WEST SUSSEX COUNTY COUNCIL CONSULTATION

TO:	Arun District Council FAO: Michael Eastham
FROM:	WSCC - Highway Authority: Public Rights of Way
DATE:	02nd December 2020
LOCATION:	Land South of Ford Lane east of North End Road Yapton Arundel BN18 0DS
SUBJECT:	Y/131/20/DOC Approval of details reserved by condition imposed under ref APP/C3810/W/17/3170059 (Y/80/16/OUT) relating to Condition Nos 7 - means of access/egress onto Ford Lane, 8 - retention & improvement of Public Rights of Way 357, 358, 359 & new cycle & pedestrian routes, 9 - Stage 1 Road Safety Audit, 12 - Travel Plan and 17 - Phase 1 Habitat Survey
DATE OF SITE VISIT:	n/a
RECOMMENDATION:	Advice
S106 CONTRIBUTION TOTAL:	n/a

1. Condition 8 (retention and improvement to Public Rights of Way 357, 358 and 359 and new cycle and pedestrian routes)

Drawing Title
Sections through public right of way footpath 357

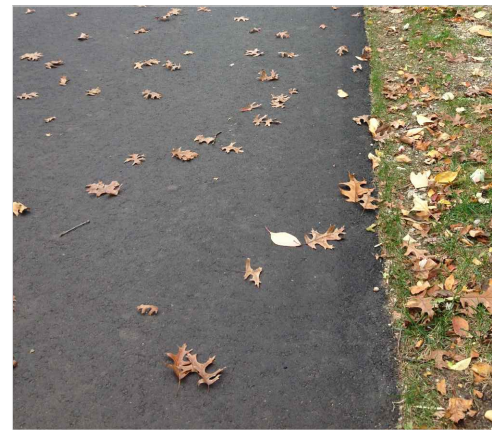
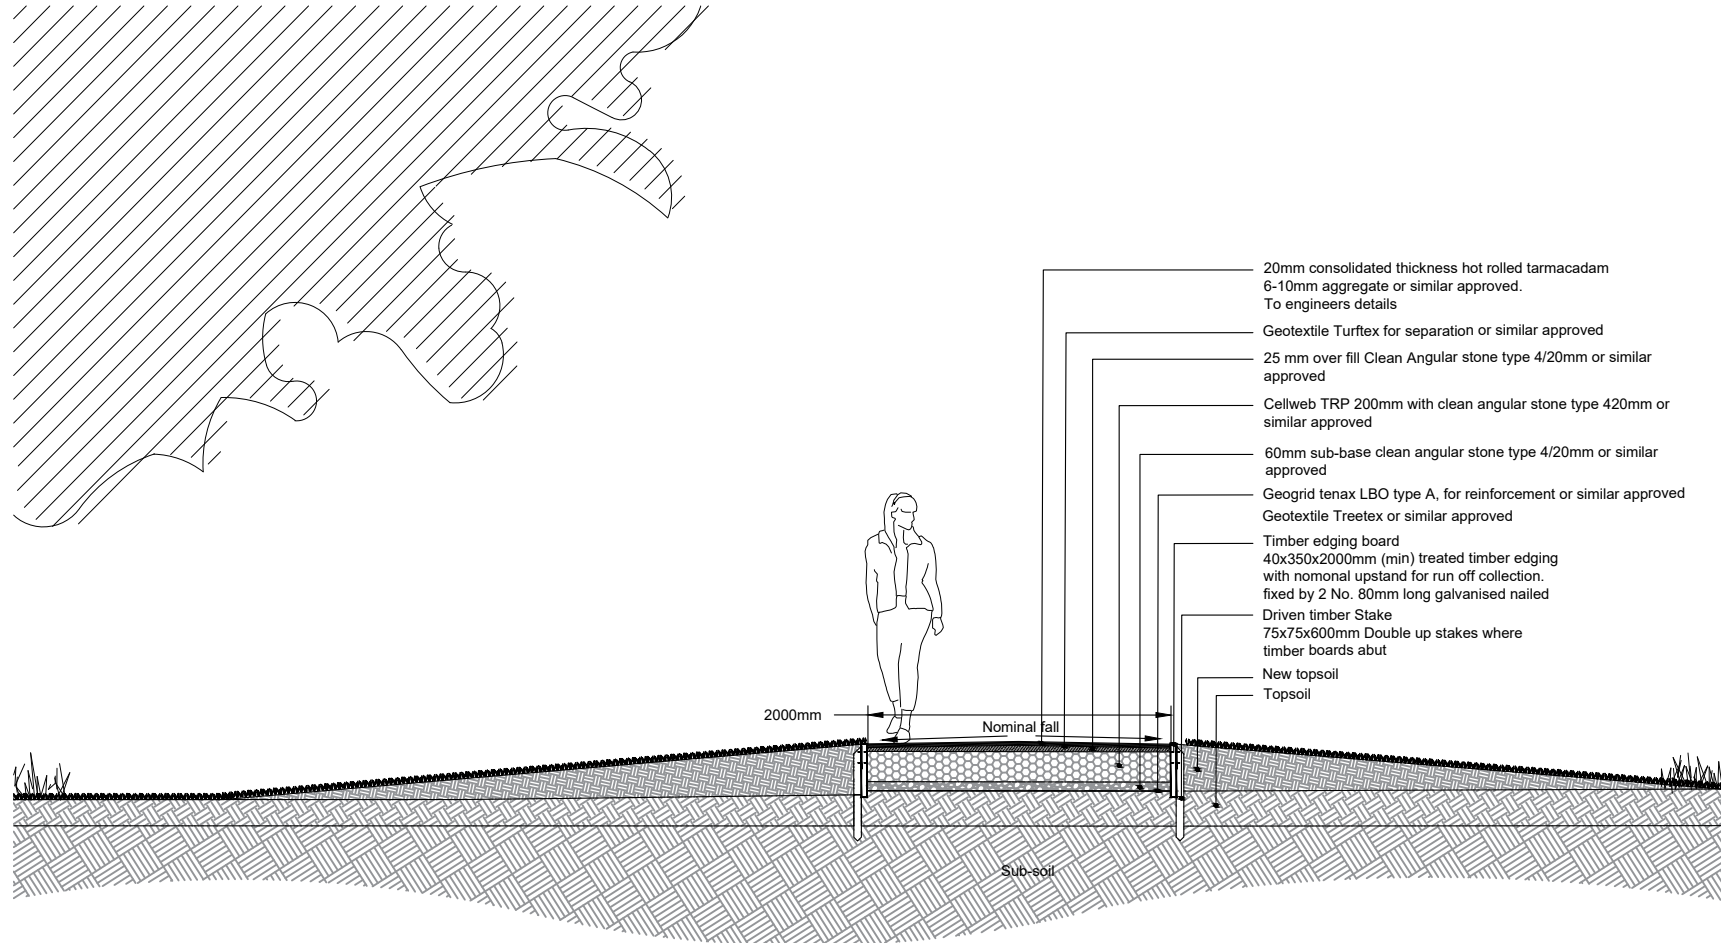
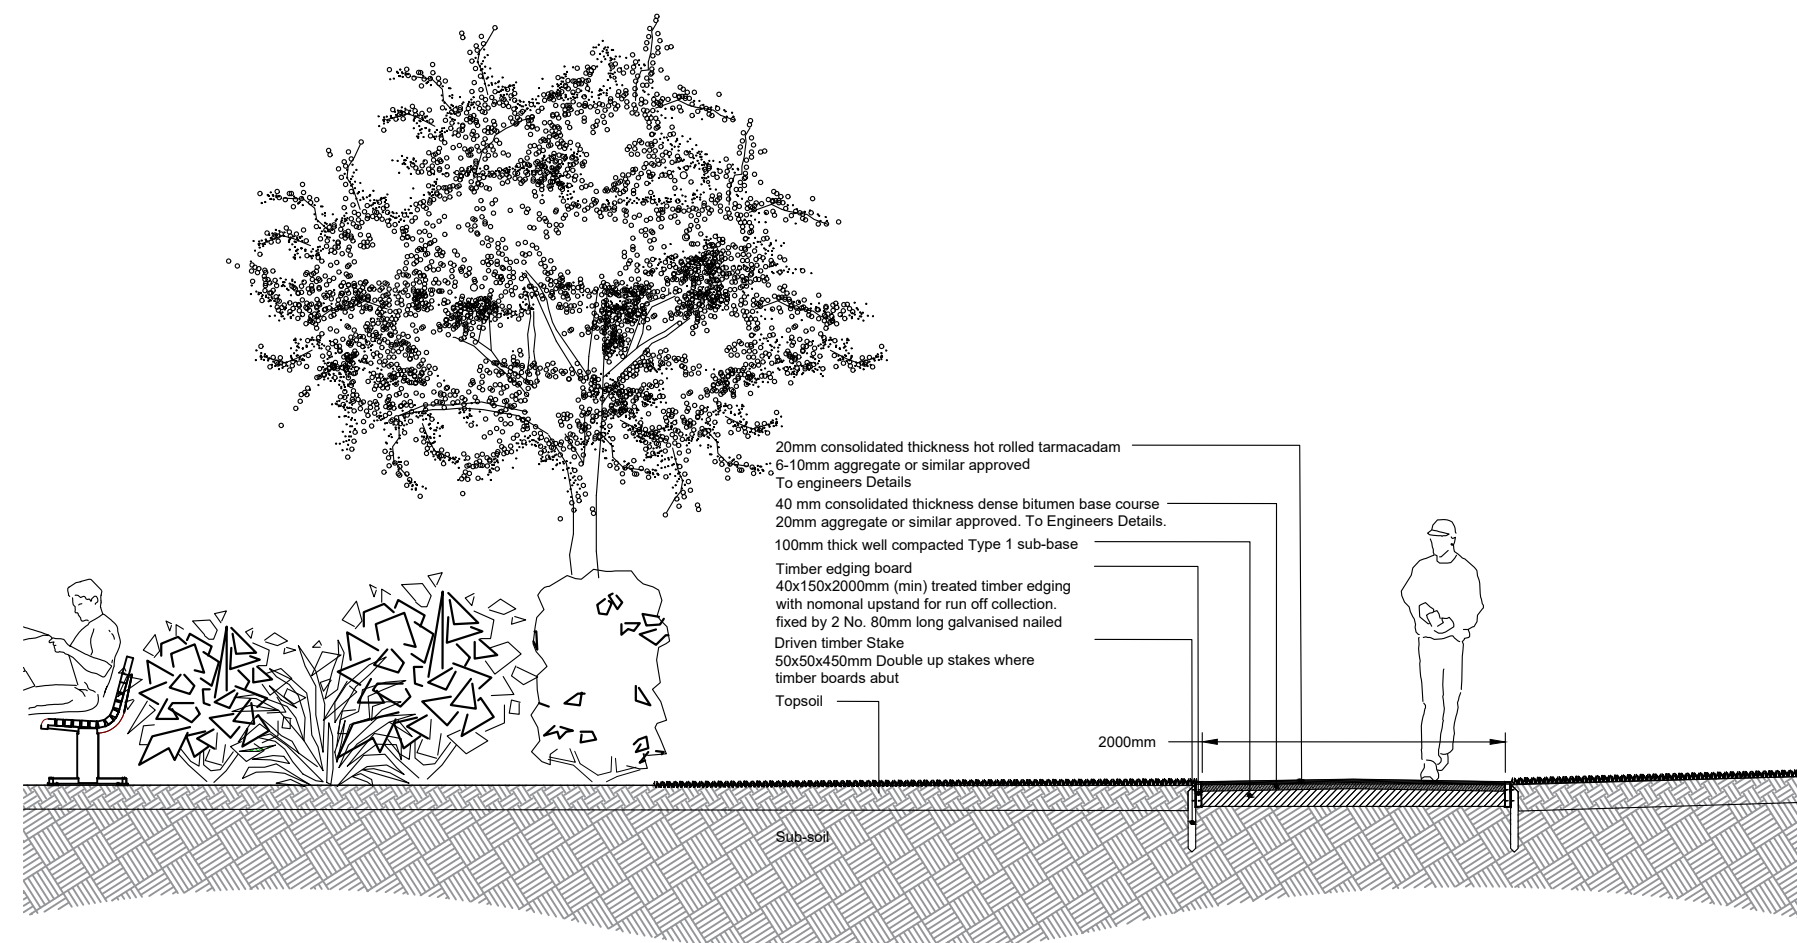
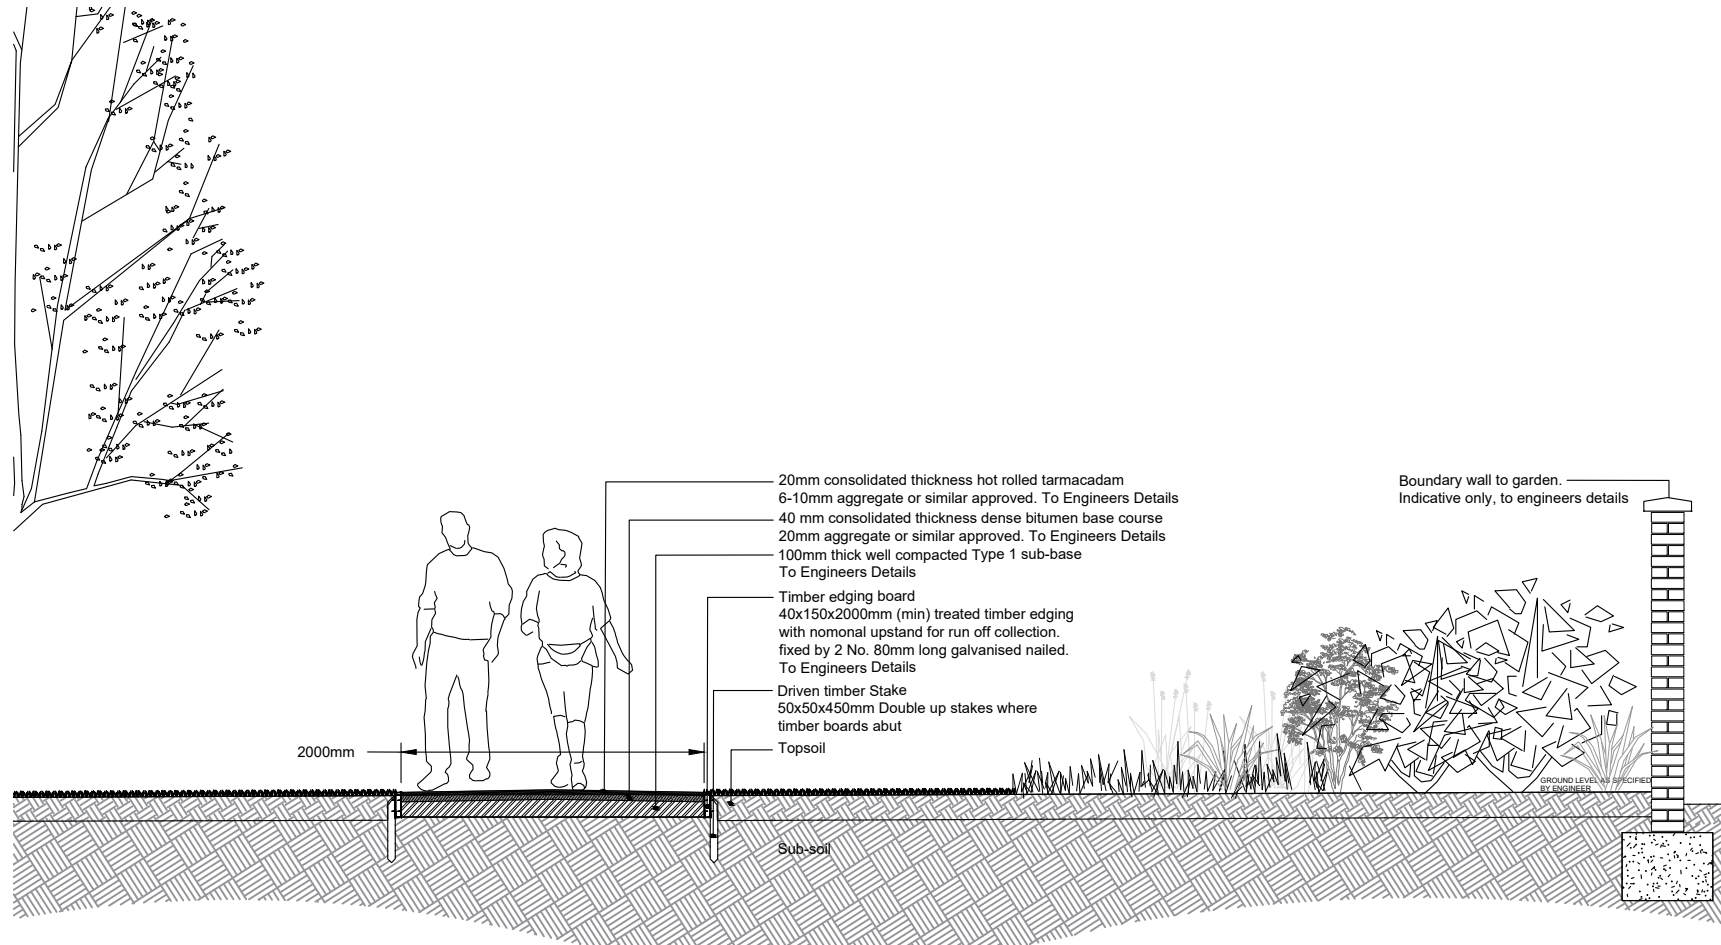
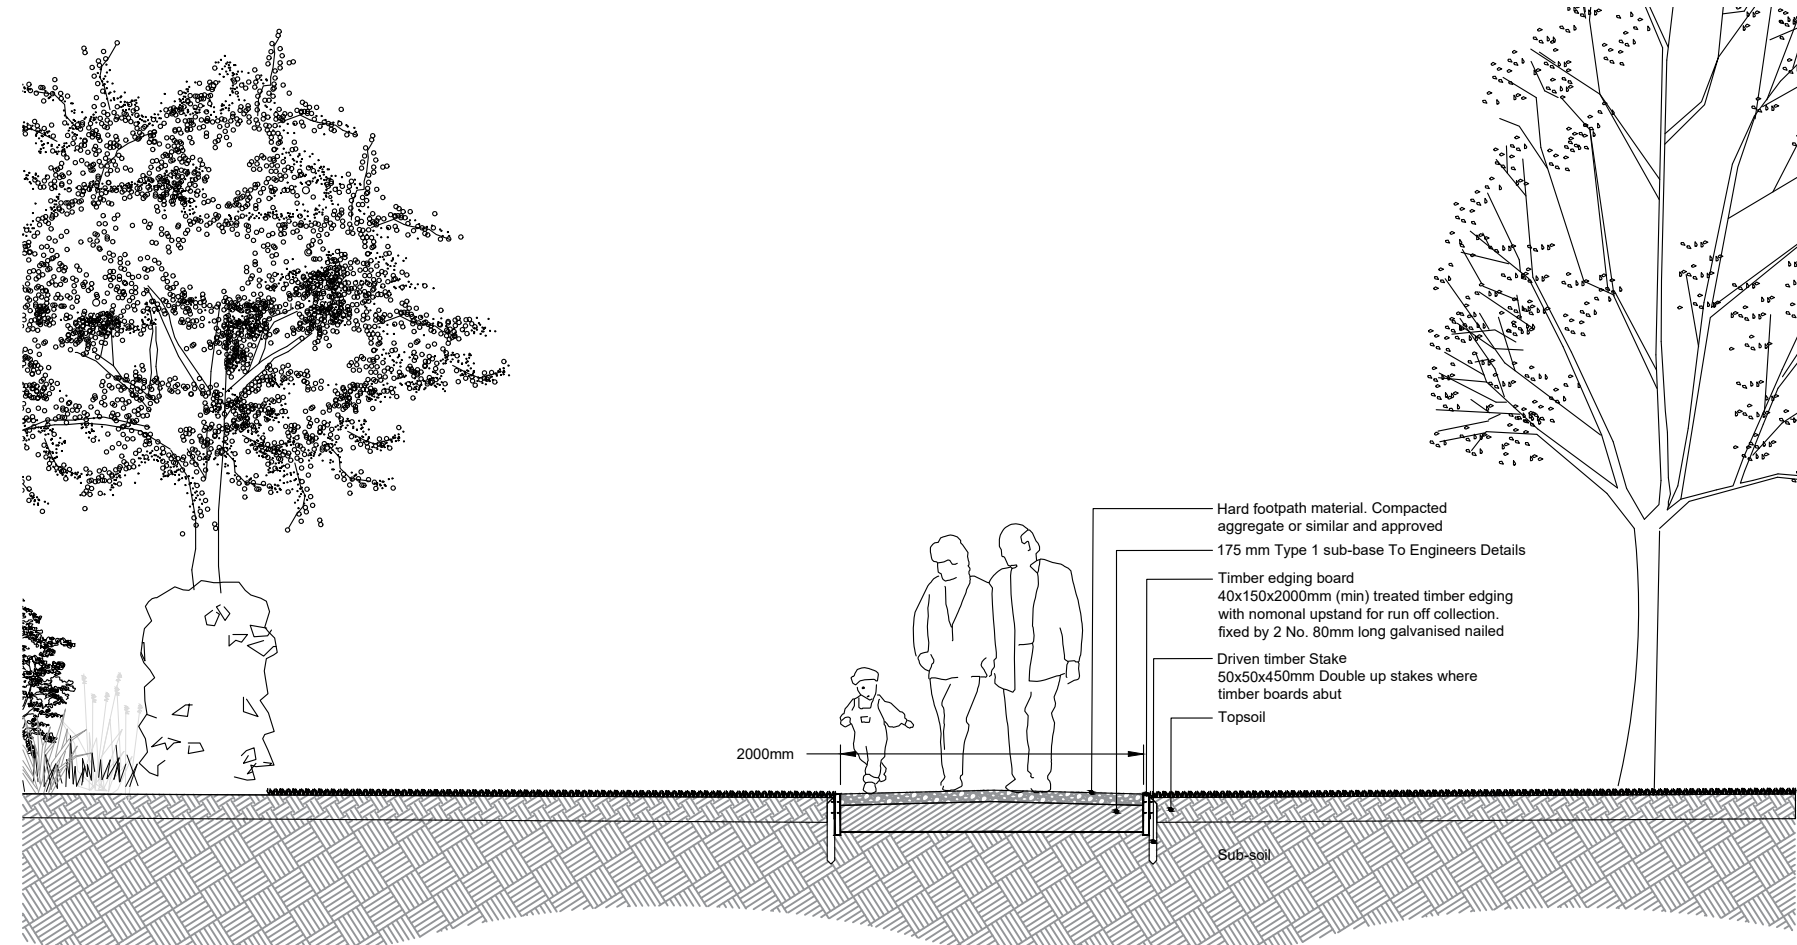
Whilst some discussion has already taken place with regards to FP358 and its dedication to Bridleway status, I would echo the thoughts of Tim Townsend, Principle Transport Planner, WSCC, in his seeking of increased access rights over FP357 across the site also.

By also dedicating this route as Bridleway you increase the flexibility of the Public Rights of Way to include cyclists and equestrians who will seek access to the local school and amenities.

Footpath 357 allows closer access to North End Road, at the North West corner of the development and potential onward links to Maypole Lane and a short section of Bridleway that crosses the railway line.

An alternative, were the planning authority only to agree upon FP358 being dedicated as Bridleway along the Eastern boundary, as already discussed, would be to formalise permissive cycling rights along FP357. This would ensure flexibility for residents of the development and those accessing the site and remove the potential for conflict in the future where cyclists may well use these routes despite their Footpath status.

Should both routes be formally dedicated as Bridleways we would seek 3m minimum width and surfacing as per our specification which will require specific materials to meet equestrian needs. If FP357 is to allow cycling and pedestrian access only, the surfacing material will not need this specific type but can be agreed in due course. It will however still require a minimum of 3m to ensure safe separation between cyclists and pedestrians.
